Description: Change of use from doctor's practice to 7no. apartment and 1no. studio flat including external extensions and alterations to building.

Site Address: Caxton House Surgery, 53 High Street, Grimethorpe, Barnsley, S72 7BB.

0m 1m 2m 3m 4m 5m			
Rev.	Description	By	Date
Project 53 High Street Grimethorpe Barnsley			
S72 7BB			
Drawing Title Proposed Floor Plans			
Drawing No. High/03	Rev.	Drawn by J.S.	Scale 1:50@A1
		Date Jul '22

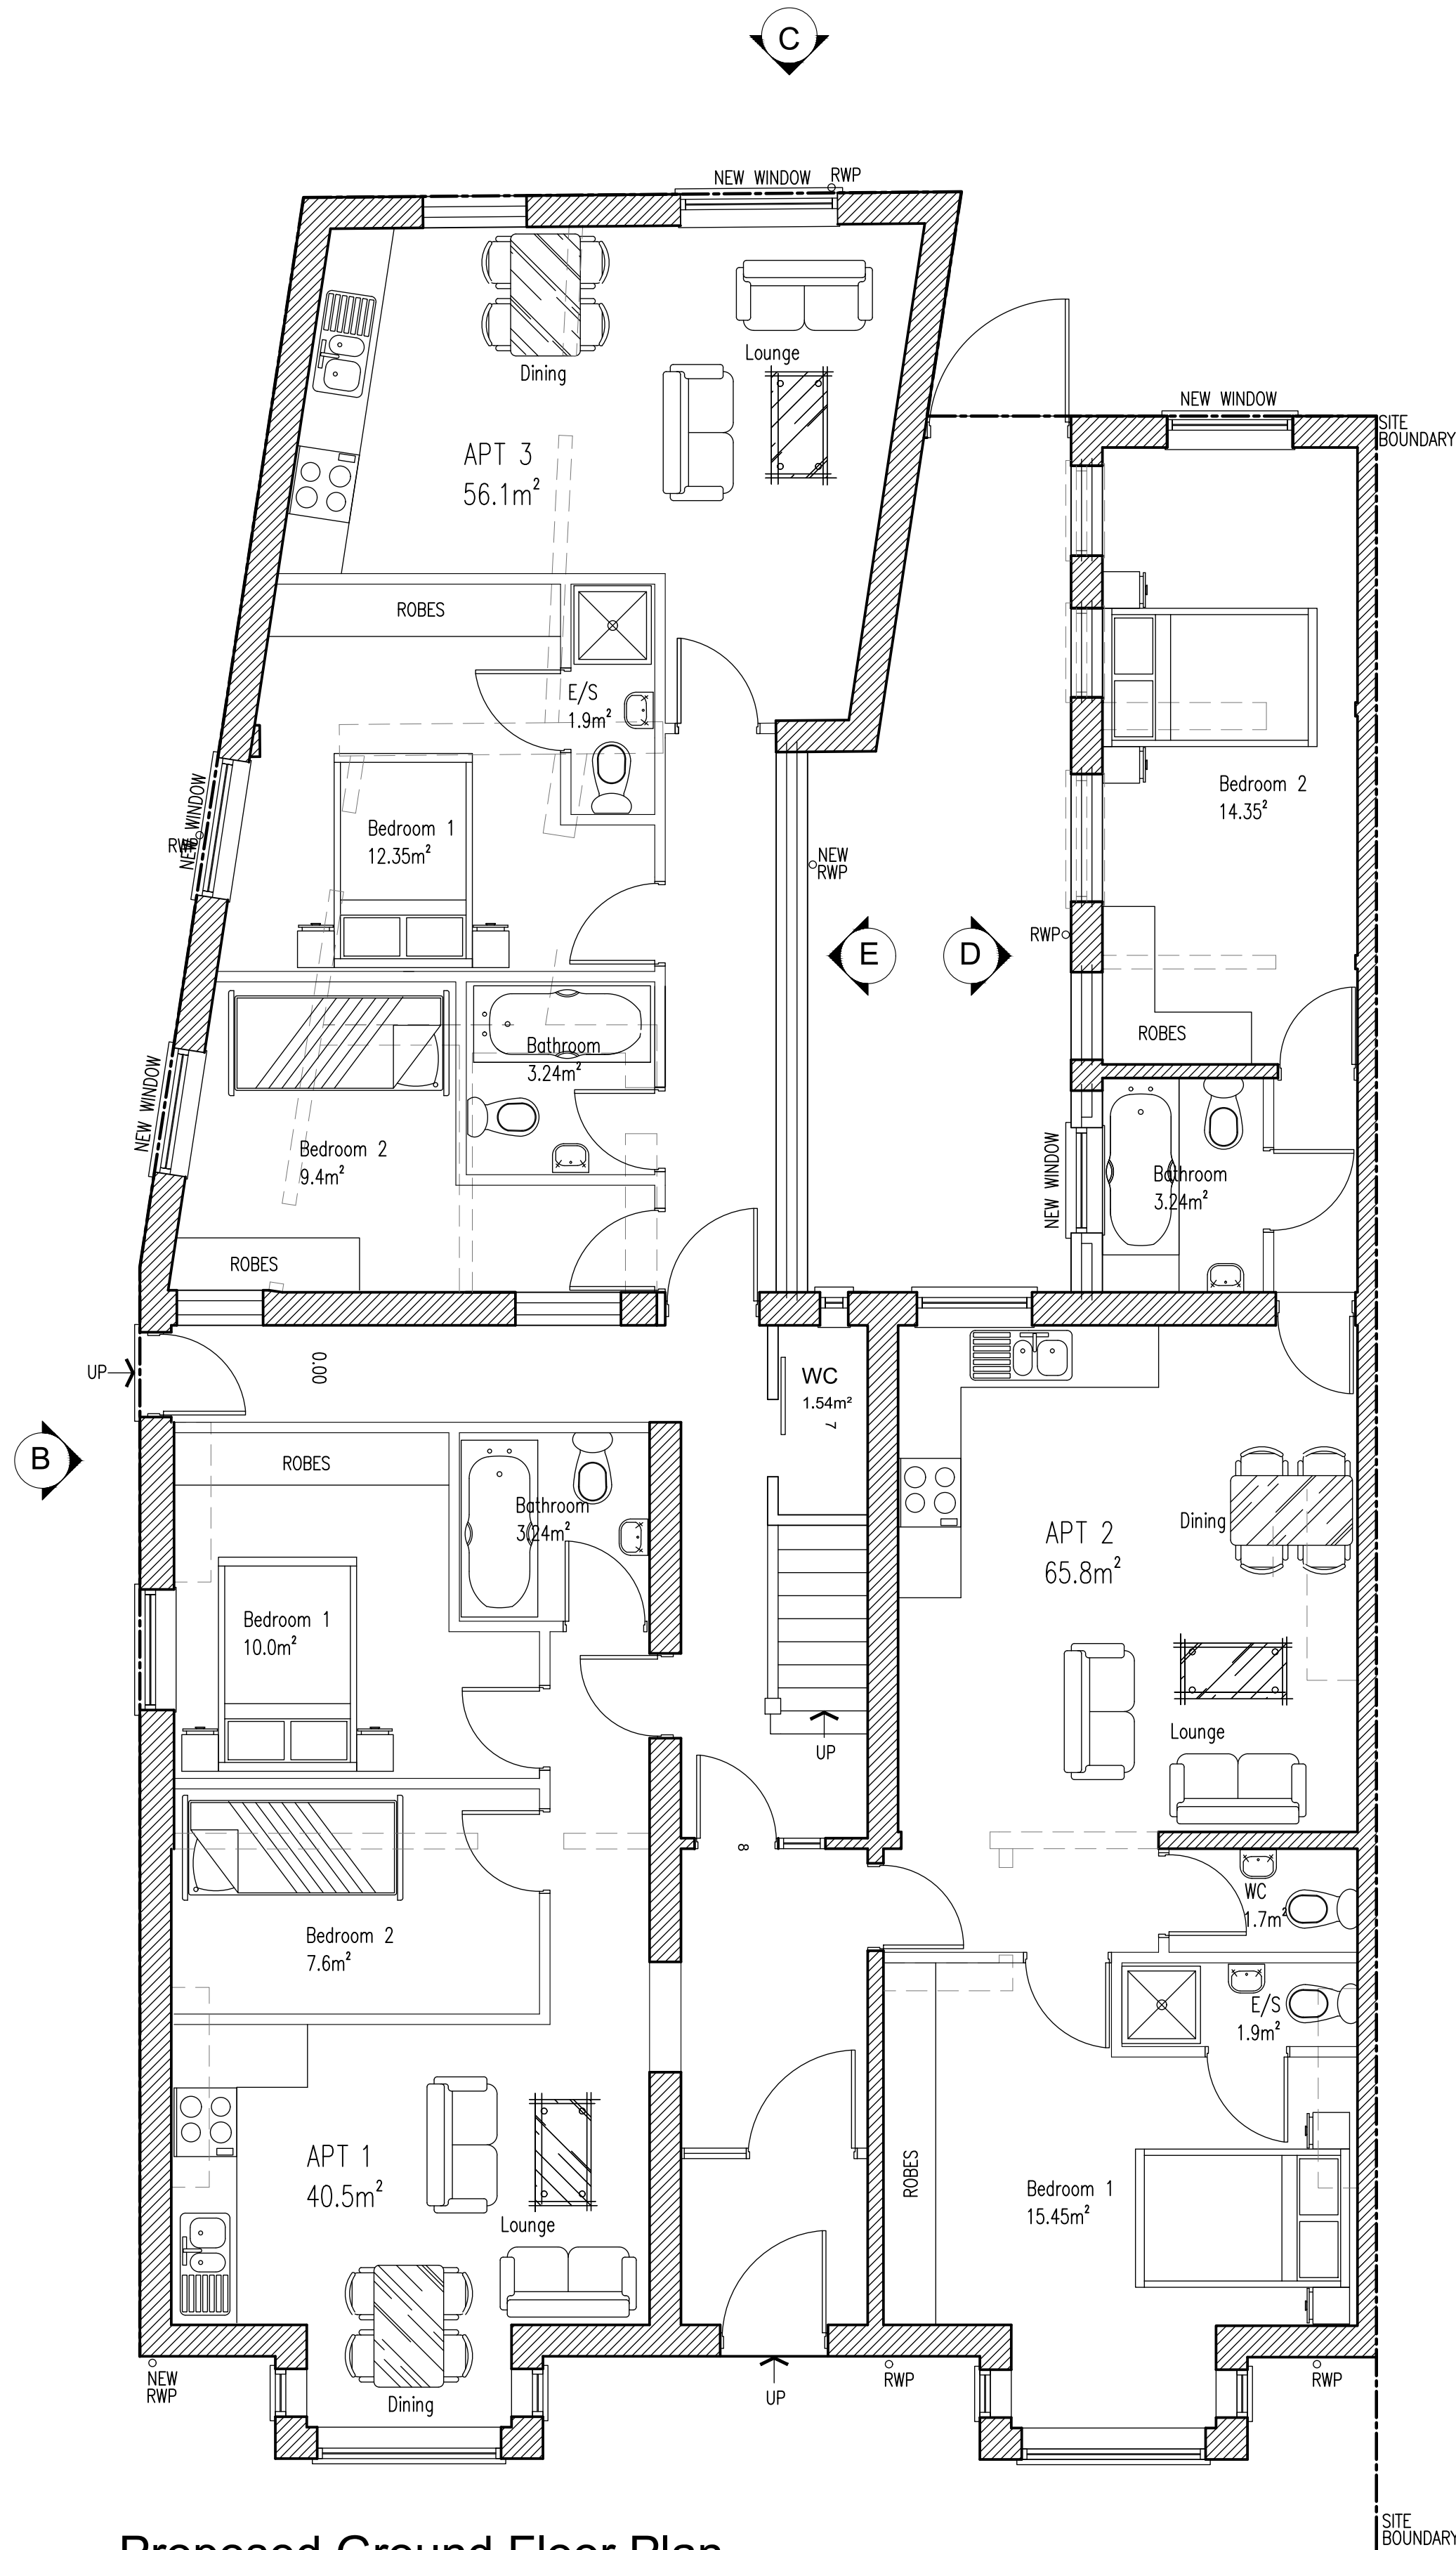
The double bedroom in apartment 1 at 10sqm has a shortfall of 2sqm, the open plan/ combined kitchen/diner/lounge (KDL) falls short at 16.08sqm compared to the standard of 27sqm and the bathroom falls short at 3.24sqm compared to the standard of 3.5sqm, with the overall apartment being substandard at 40.55sqm, falling short of the 62sqm standard for a 2 bed, 3 person apartment. The combined KDL in apartment 2 falls short at just 20.5sqm and the bathroom again falls short, although the apartment achieves an overall floor area of 65.8sqm which would comply with the standard for a 2 bed 3 person apartment. Apartment 3's KDL falls short at 21sqm, the bathroom again falls short and there is an overall shortfall in overall floor area at 56.1sqm for a 2 bed, 3 person apartment. The double bedroom in apartment 4 falls short by 1.5sqm, the bathroom and KDL are substandard at 3.24sqm and 18.39sqm, in addition to the overall floor area at 46.3sqm for a 2 bed, 3 person apartment. The double bedroom, bathroom and KDL in apartment 5 fall short at 11.7sqm and 13.66sqm and 3.24 and the overall floor area is substandard at 32sqm instead of 46sqm for a 1 bed, 1 person flat. Apartment 6 is a 1-bedroom studio flat with a substandard bathroom at 1.9sqm and an overall incompliance to the standards at 22sqm for total floor space instead of 33sqm. Apartment 7 has a substandard bathroom and KDL at 3.24sqm and 21.7sqm and the overall floor space does not comply at 43sqm for a 1 bed, 1 person flat. Alike apartment 7, apartment 8 does not comply with any of the standards with a bathroom of 3.24sqm, a KDL of 18.74sqm and an overall floor space of 40sqm for a 1 bed, 1 person flat.

In addition to the above, it is considered that the outlook and availability of light for future occupiers is substandard in some of the apartments. Bedroom 2 of apartment 1 is not served by a window and thus would not receive any light nor have any outlook; apartment 6 (the studio flat) is a single aspect flat and would be served by a single small window which would not ensure an adequate amount of light or outlook and the bedrooms of apartments 7 and 8 are not served by a window and only small velux rooflights which again would not be sufficient outlook nor allow for sufficient light for a 1 bedroom, 1 person flat.

0m1m2m3m4m5m				
Rev. Description			By	Date
Project 53 High Street Grimethorpe Barnsley S72 7BB			NORTHWEST	
Drawing Title Proposed Site Plan				
Drawing No.	Rev.	Drawn by	Scale	Date
High/06		J.S.	1:50@A1	Jul '22

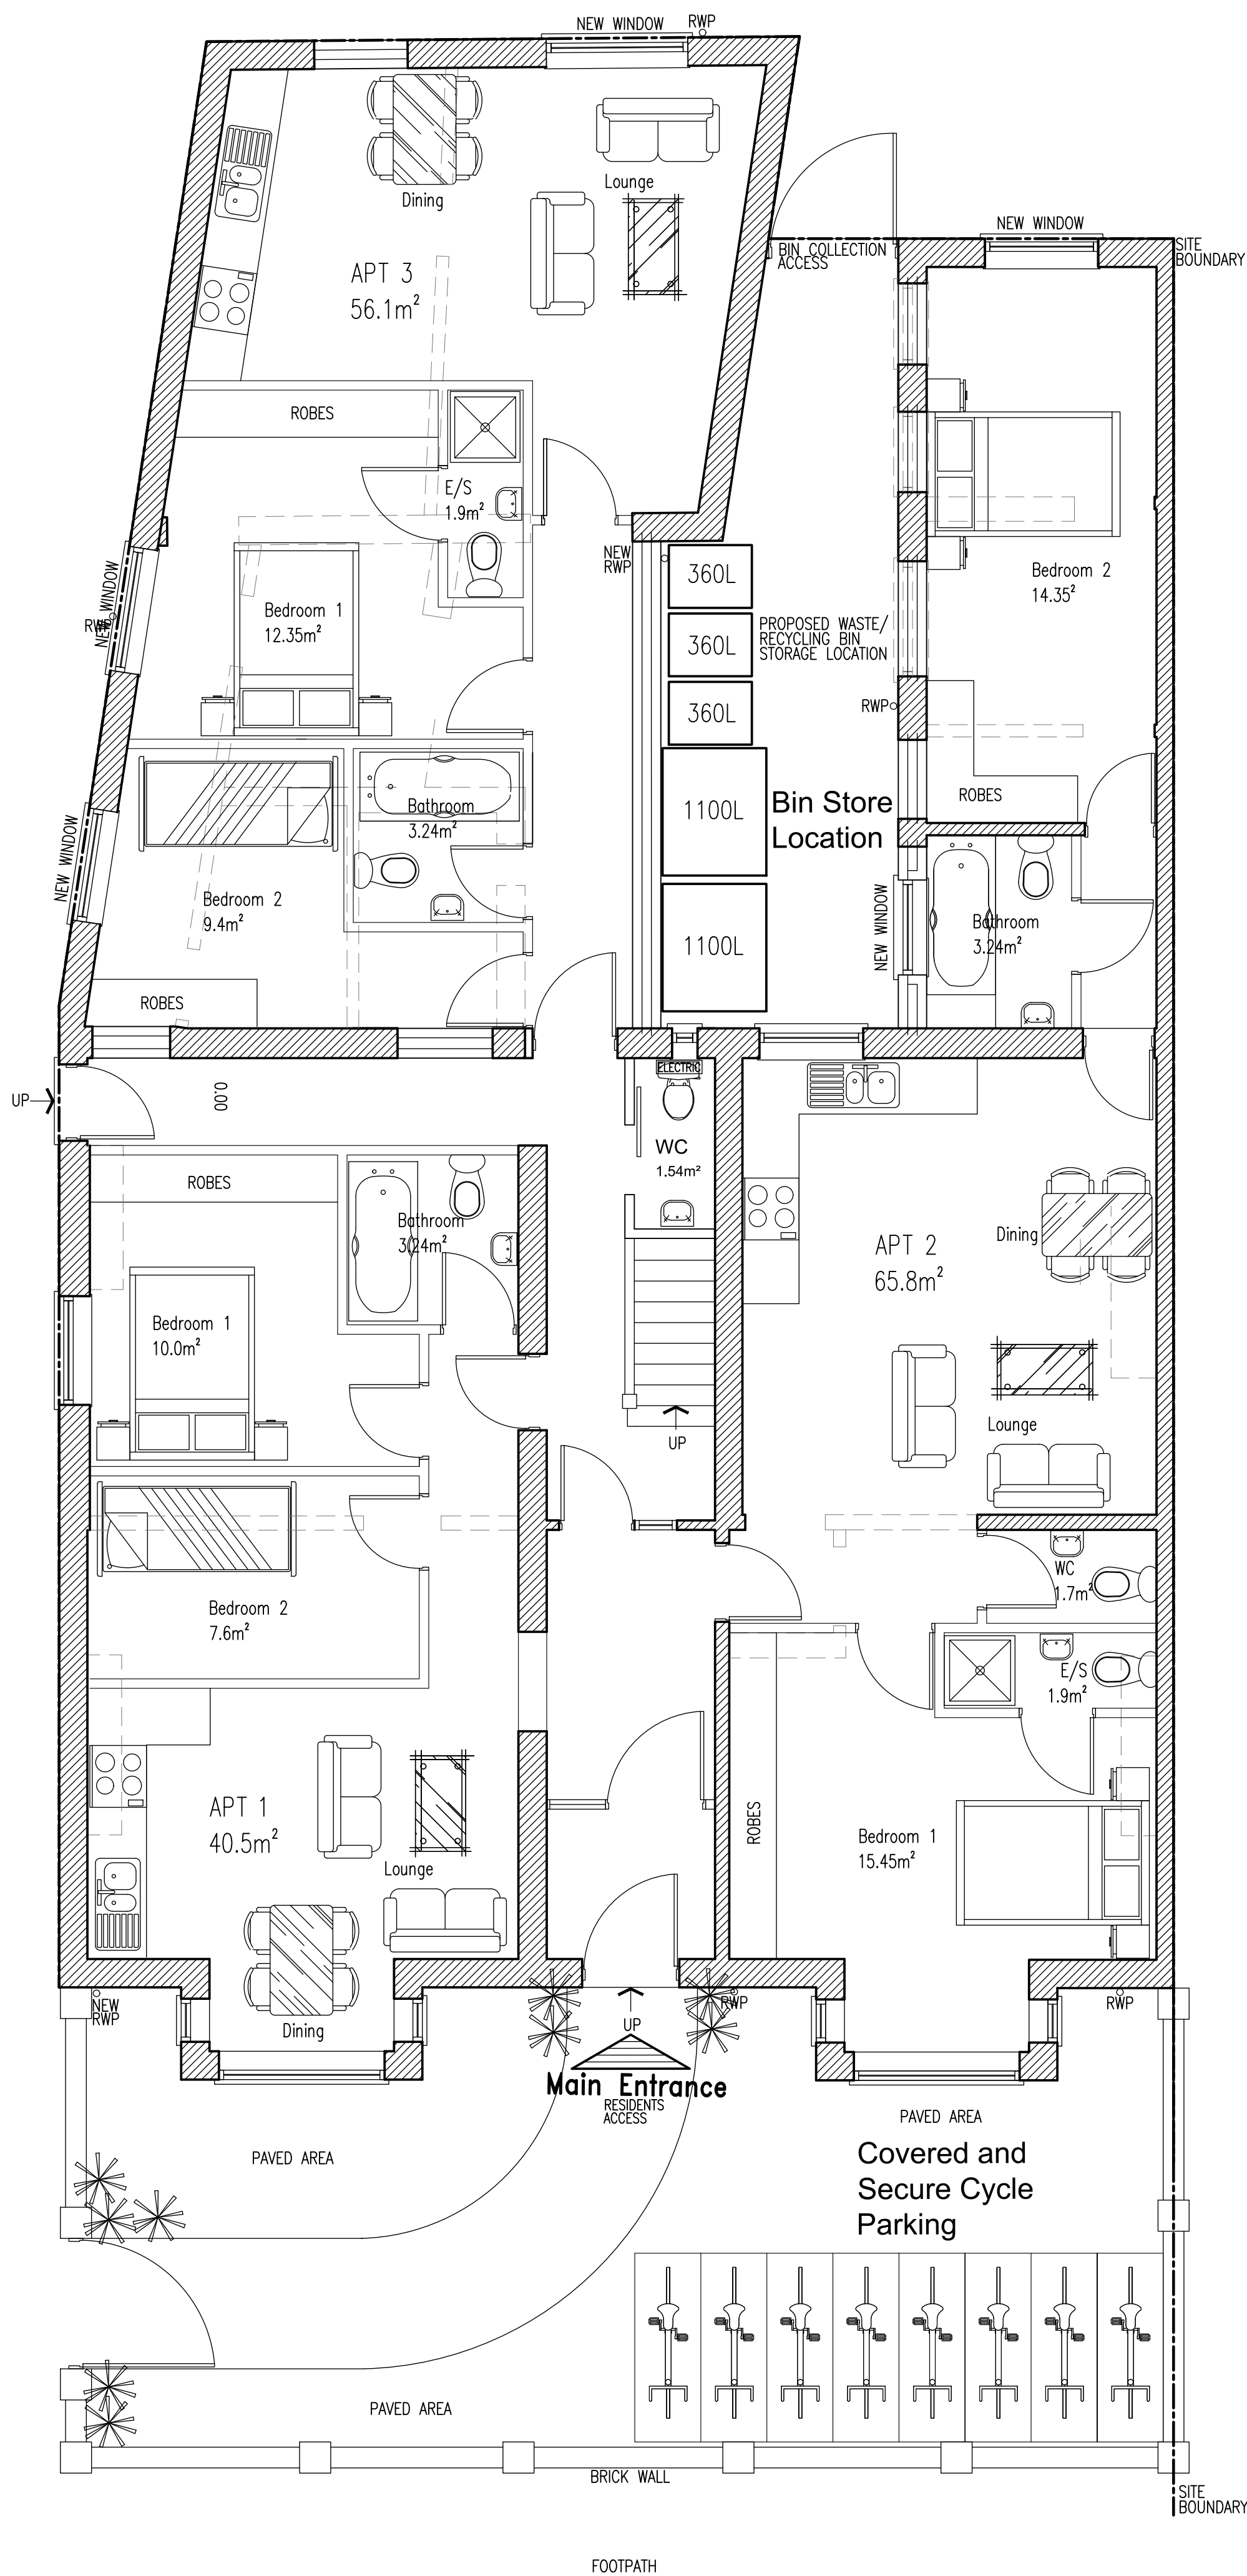
The South Yorkshire Residential Design Guide states that back gardens of houses should be appropriate to the size of the property, its orientation and likely number of inhabitants. For two bedroom houses this should be 50sqm and for three bedroom houses should be 60sqm. The guide goes on to explain that shared private space for flats must be a minimum of 50 square metres plus an additional 10 square metres per unit either as balcony space or added to shared private space. The proposed development is not served by any private amenity space and there has been no justification given in the planning statement for the shortfall of amenity space. Although the irregular shape of the site lends itself to having no amenity space, works could have been undertaken to the rear of the property to free up space by reducing the number of units the proposal would create. Neighbouring properties adjacent to the site benefit from amenity space and as such this shortfall is not common of the area. As such the proposal is unacceptable from an external amenity point of view.

Barnsley SPD Parking (2019) Table 2 Cycle Parking Standards requires that 1 secure and undercover cycle parking space is provided per dwelling. 8 cycle spaces have been provided for the flats which will be acceptable but should be conditioned for retention
